DECISION DELEGATED TO HEAD OF PLANNING

Application No: H02-0902-25 **Applicant:** Dr L Edensor
Proposal: Erection of single storey rear extension & pergola structure, erection of first floor extension & alterations
Location: 23 Normanton Road Crowland Peterborough
Terminal Date: 5th December 2025

Client Dr L. Edensor		Project Proposed extensions and alterations at 23 Normanton Road Crowland		
Drawing Proposed Site Plan/Block Plan				
Date Aug 2025	Scale 1:200 @ A3	Project No. 596	Drawing No. 02	Revision A

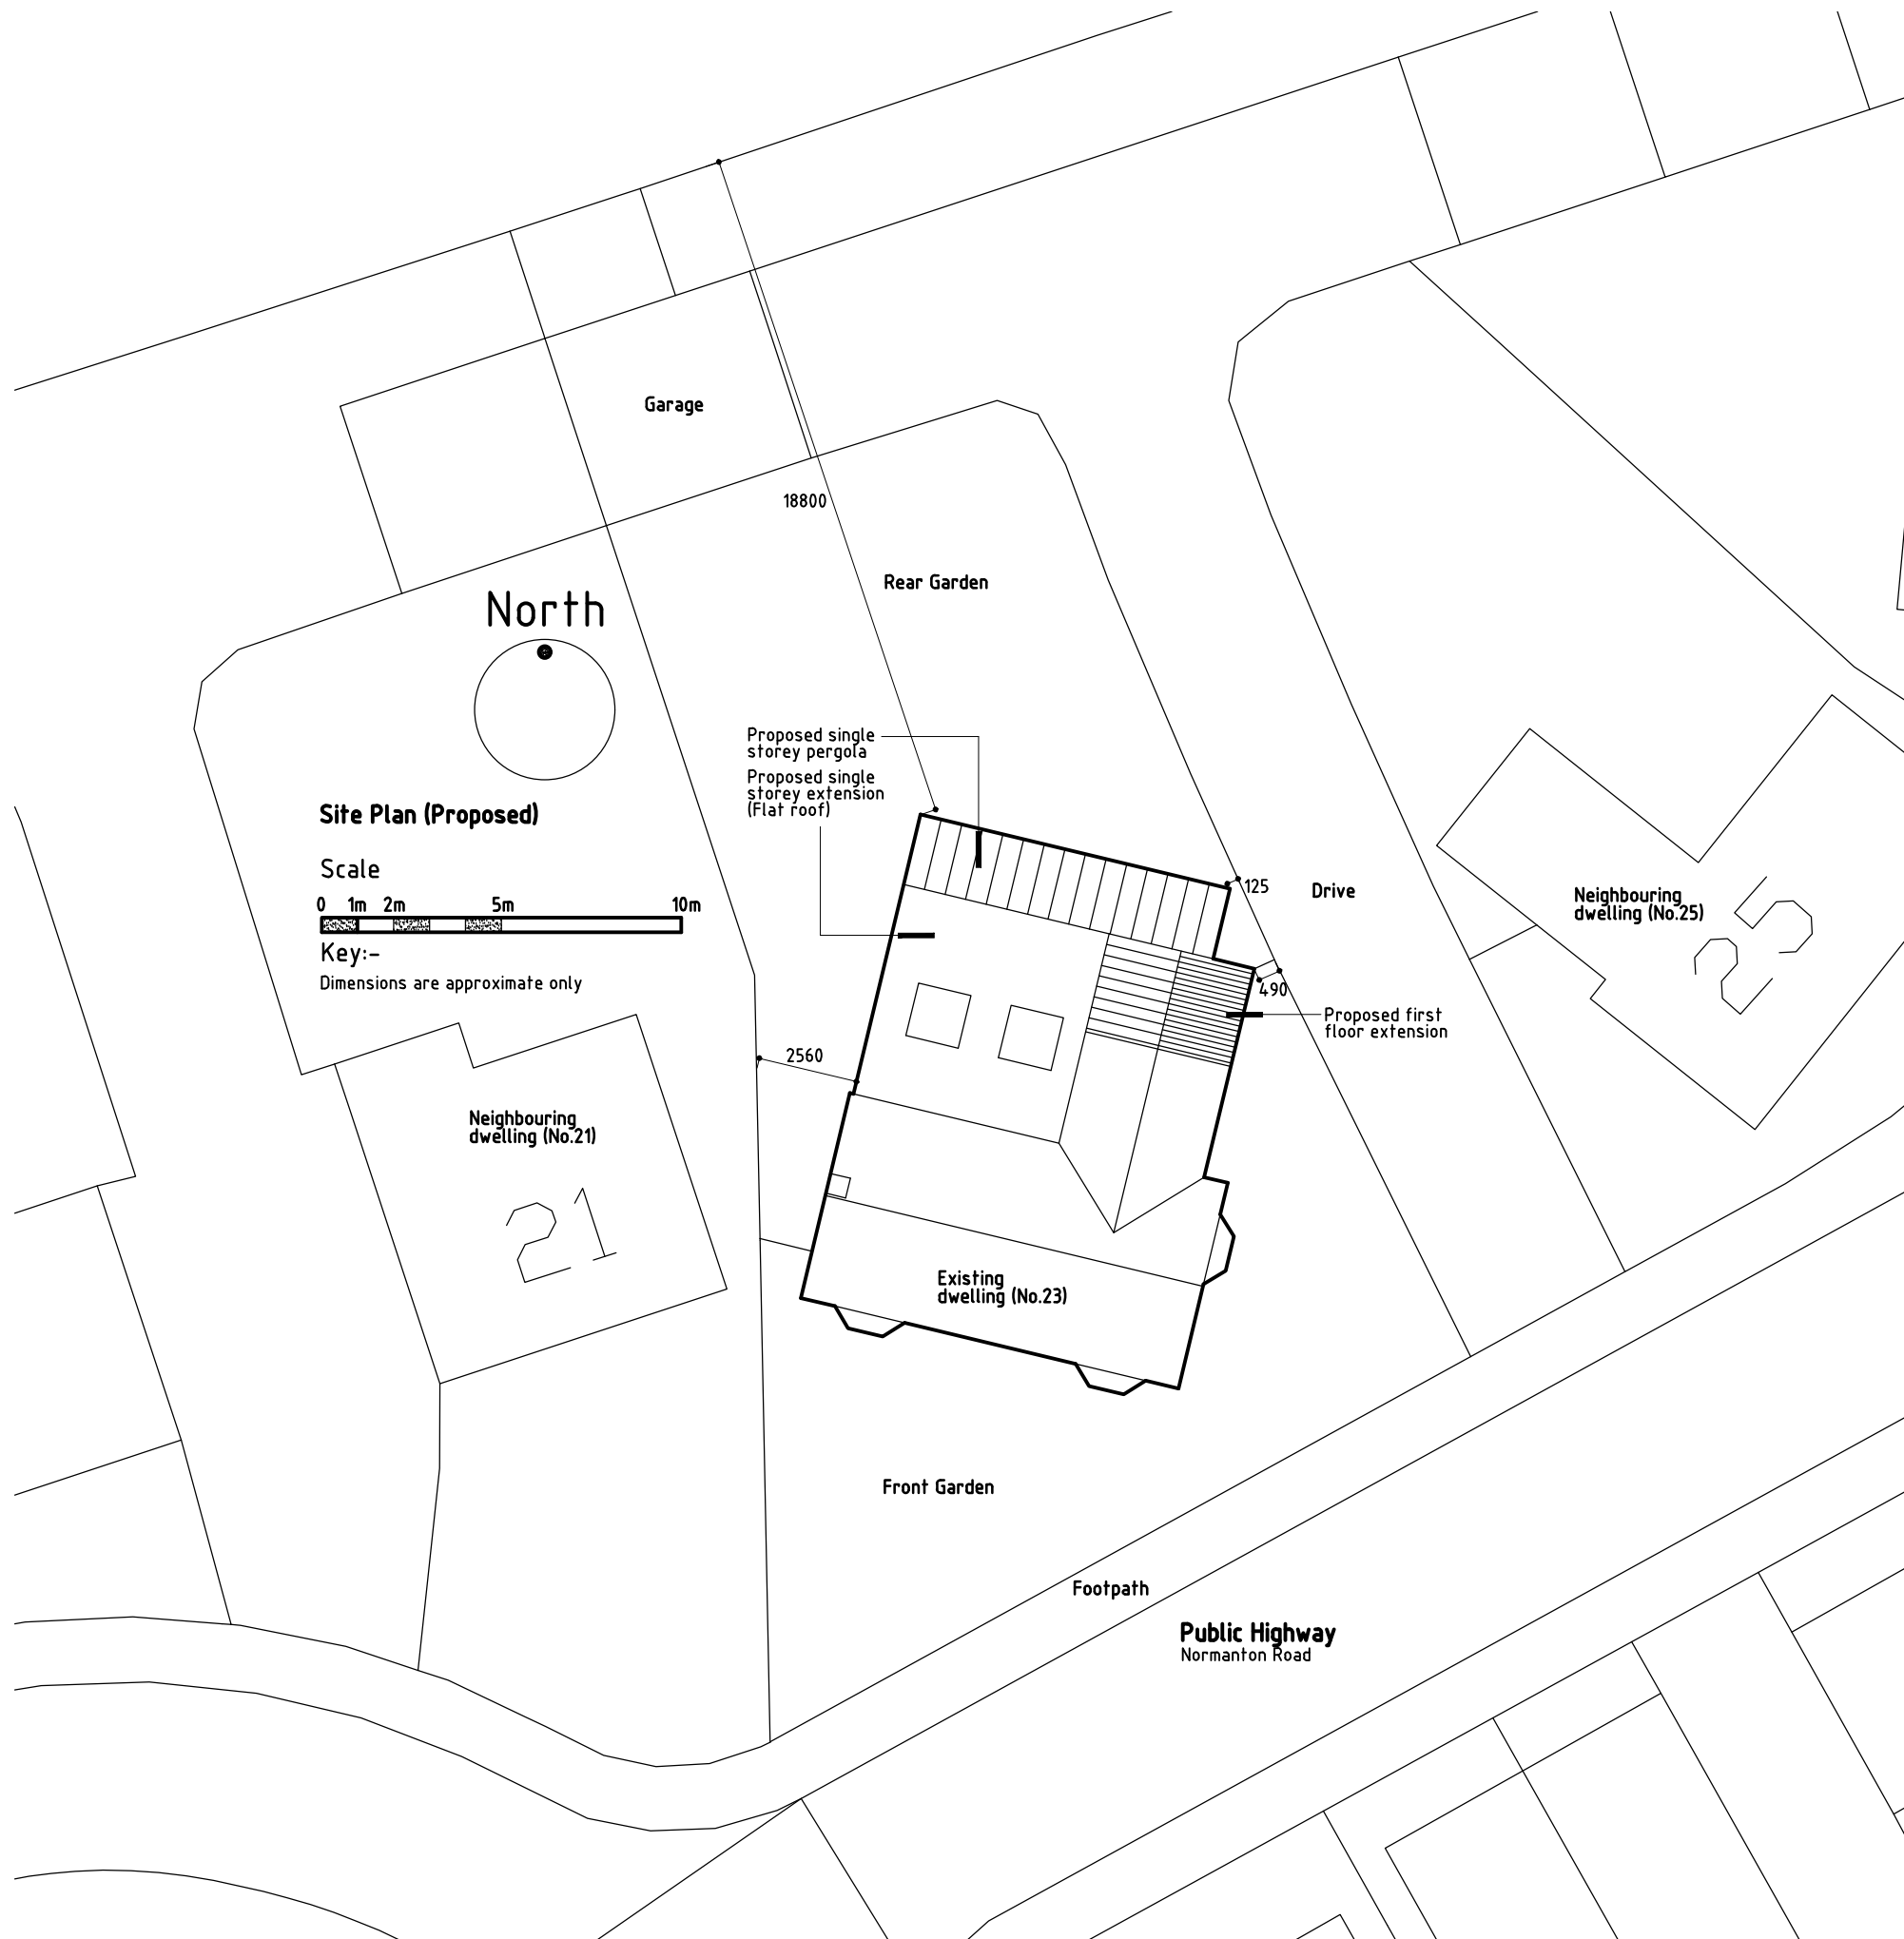
Firstly, the pergola would have a height of 2500mm and would be made from metal with a solid/glazed roof. It would span a total length of 8800mm and would project beyond the rear of the single storey extension. Whilst this is of a fairly large scale, it would be mostly concealed from prominent views and therefore would not be harmful in this regard.

The first floor rear extension is not considered to result in any material overshadowing to either neighbour due to the distances provided. Furthermore, the single storey rear extension is also not considered to result in any material loss of light due to it being solely a ground floor extension with a height of 3100mm whilst also having suitable separation distances. Overall, no material loss of light should occur in this regard.

Client Dr L. Edensor		Project Proposed extensions and alterations at 23 Normanton Road Crowland		
Drawing Proposed Floor Plans				
Date Aug 2025	Scale 1:100 @ A3	Project No. 596	Drawing No. 06	Revision -

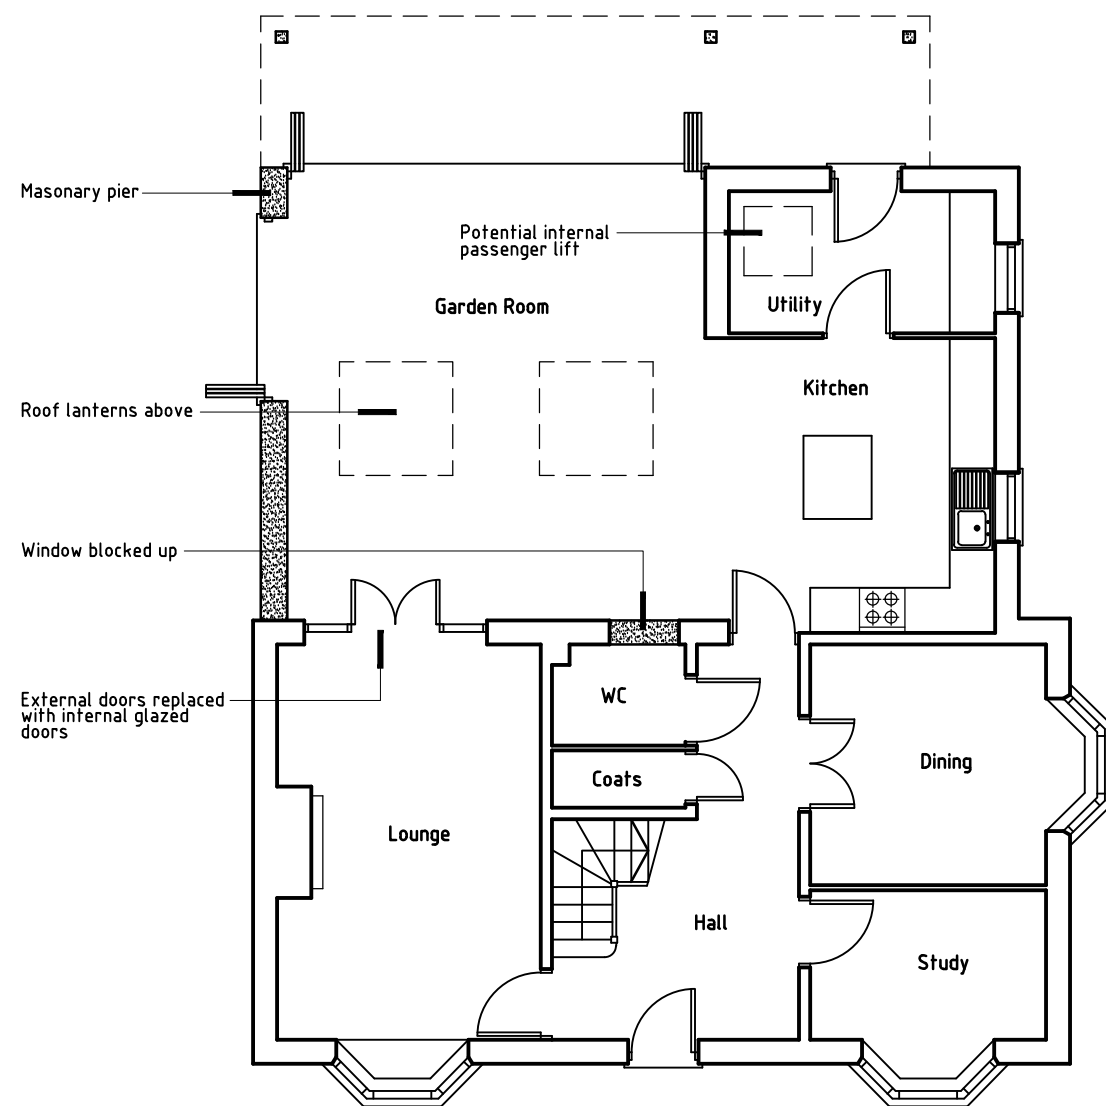
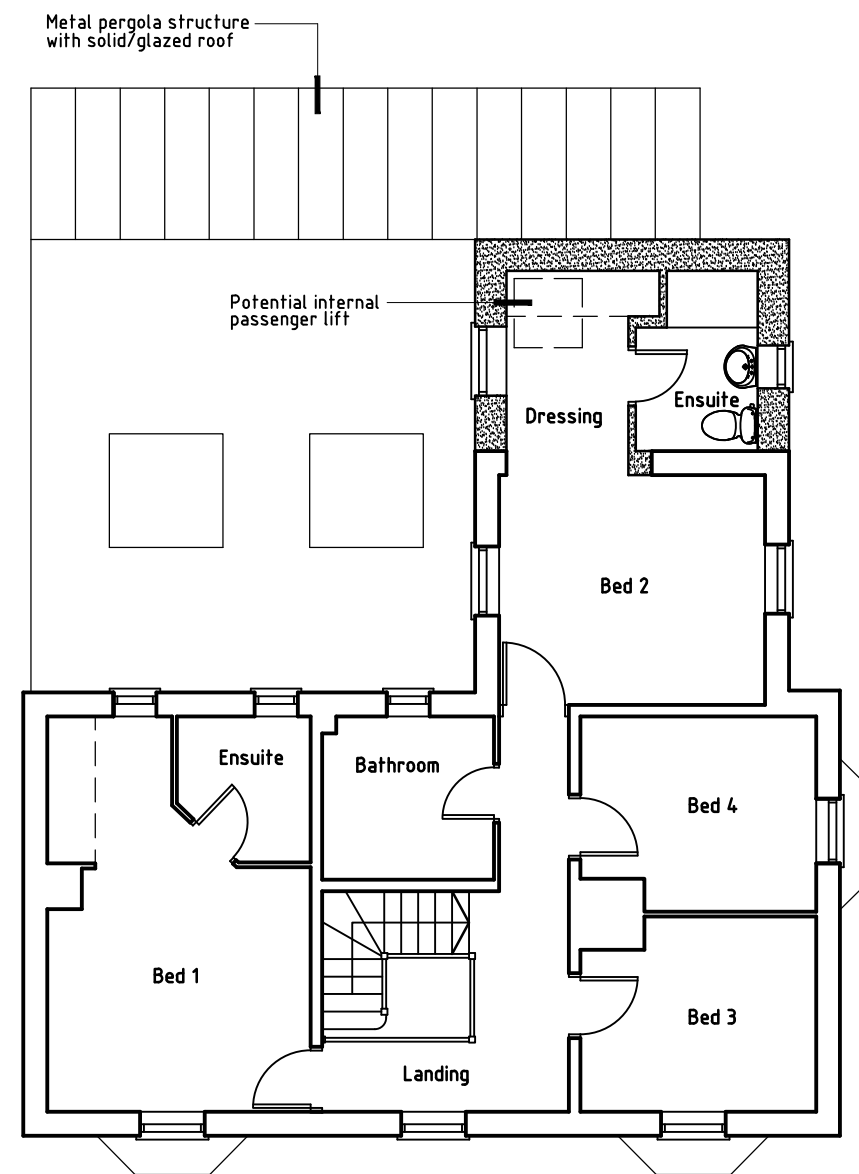
The first floor extension would have the same width as the existing gable projection, and would sit on a similar footprint to the ground floor section, by extending out by around 2800mm. Whilst the direct neighbour, in its current form, has somewhat of an identical construction to that of the existing host dwelling and therefore this first floor extension could be somewhat out of character in this regard, as it would be set to the rear of the site, it would mostly be concealed from prominent views and only partially visible when travelling out of the estate. As such, the first floor extension is also considered to be acceptable and proportionate in this regard.

No new windows are proposed along the rear elevation; however, one window is proposed on either side of the first floor rear extension. One of these windows would be for an en-suite for Bedroom 2 and therefore would naturally be obscure glazed, whilst the window on the opposite side would be for the dressing room within this same bedroom. This dressing room window would face out onto the host properties garden and could provide a view, to some extent, into the neighbouring properties rear garden also.

Notwithstanding this, there is already a window on this same elevation for the Bedroom 2 and therefore this window would not provide any additional views, that would amount to an unacceptable level of additional harm. As such, there is not considered to be any material overlooking concern that is not at an already existing level.

The existing dwelling has four bedrooms on the first floor, the extension would not increase the number of bedrooms on site but would see an increase in the overall floorspace for Bedroom 2. There is ample parking which is set to the rear of the site which allows the dwelling to accommodate the necessary three vehicles on site. Furthermore, LCC Highways have raised no objections to the proposal from a highway safety perspective.

Client Dr L. Edensor		Project Proposed extensions and alterations at 23 Normanton Road Crowland		
Drawing Proposed Elevations (Sheet 1 of 2)				
Date Aug 2025	Scale 1:100 @ A3	Project No. 596	Drawing No. 07	Revision -

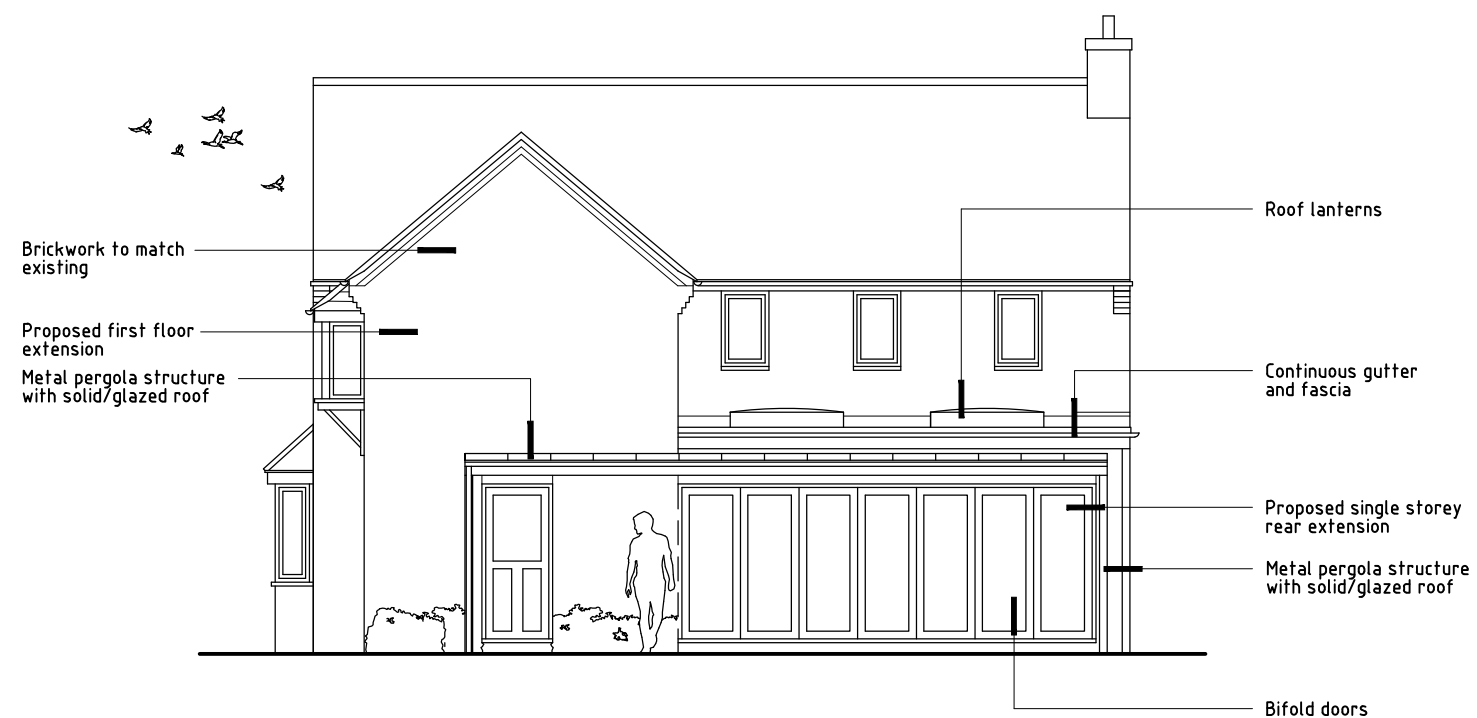
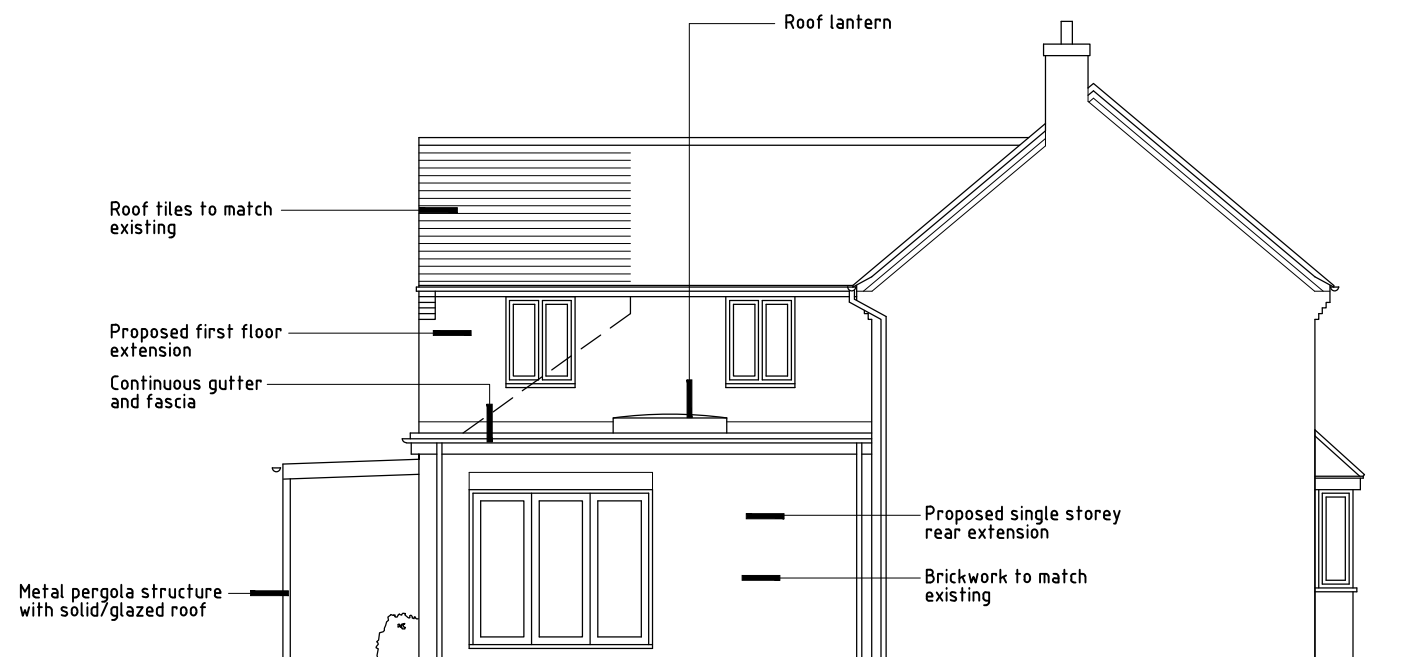
The ground floor extension would protrude from the rear elevation by around 6000mm, to be level to the rearmost point of the existing house (existing rear projection). The proposed extension is designed as to comprise a flat roof design, providing a height of roughly 3100mm. Whilst flat roofs

are not commonly favourable, the extension would be mostly concealed along Normanton Road and would only be visible via the private access/drive travelling to the rear of the site. The single storey extension in this regard is therefore considered to be acceptable and proportionate in relation to the host dwelling.

Finally, the first floor extension would extend above an existing projection, and would comprise a maximum height of 6900mm, providing a height that would be level to the height of the main dwelling. Whilst this would, therefore, not be subservient, the extension is not considered to cause unacceptable harm as to warrant a refusal.

The materials used would match the existing dwelling throughout with the exception of the flat roof rear extension. The walls would be made from brickwork, interlocking roof tiles would be used for the pitched roof whilst a grey GRP covering would be featured on the flat roof. Both the windows and doors would be made from white uPVC. As such, this ensures that the extension ties in well with the host property as well as the surrounding area to ensure it would not harm the character or appearance of the estate.
